WEST SUSSEX COUNTY COUNCIL CONSULTATION

TO:	Arun District Council FAO: Ms Myer
FROM:	WSCC - Highways Authority
DATE:	19 November 2021
LOCATION:	65-71 Upper Bognor Road Bognor Regis PO21 1HR
SUBJECT:	BR/252/21/PL Alterations to four listed buildings involving insertion of new windows, insertion of a new staircase, repairs and reinforcement of existing timber floors and roofs, removal of internal walls, forming openings in existing internal walls, erection of new internal partitions; extension of a listed building to create an office and warden's accommodation; erection of new building consisting of 3 No. flats, offices and workshops; creation of new private gardens, separation of this part of the site from the wider University campus, creation of a shared landscaped courtyard, creation of areas for parking and storage for bins and cycles. This application affects the setting of listed buildings, affects the character & appearance of the Upper Bognor Road & Mead Lane Conservation Area and is in CIL Zone 4 (Zero Rated) as flats & other development.

7 Parking

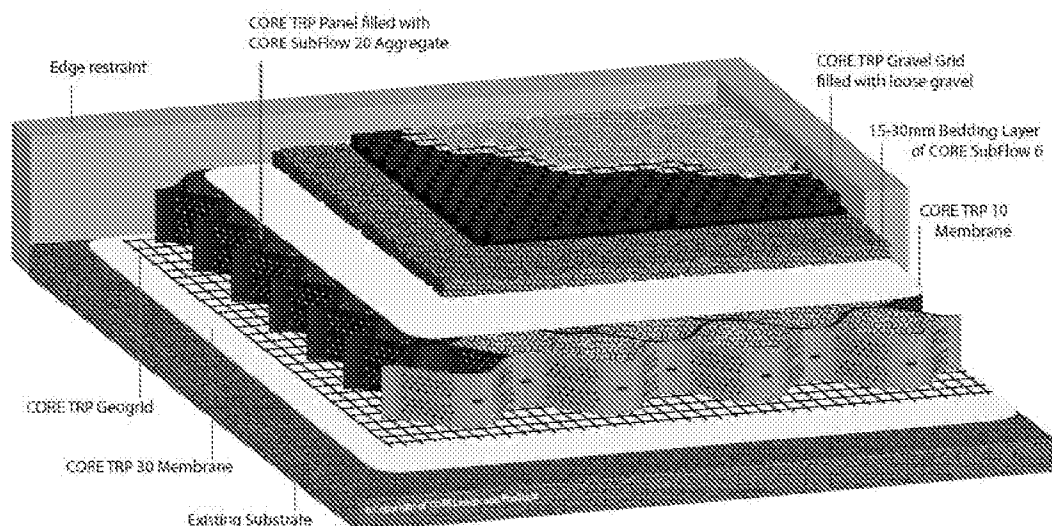
The LHA have noticed that information located in a supporting highways document states that the assessment of the site has been done on 9 dwellings. The LHA wishes to point out that the site in fact is for 10 dwellings and 2 small commercial use properties.

The LHA requests the applicant demonstrates at full extent the ability for refuse vehicles to turn within the site. Additionally, to this request the applicant may wish to investigate the internal routes within the site as it seems apparent that some parking spaces located in the northern parking area may not be accessible. We also note that the whole parking area into Charlotte House seems to be obstructed by a wall.

The applicant has demonstrated a quantity of EV parking. This, however, is below Arun's guidance on EV parking. The LHA raise no concerns over this provision, however, the LHA may wish to discuss this with the applicant.
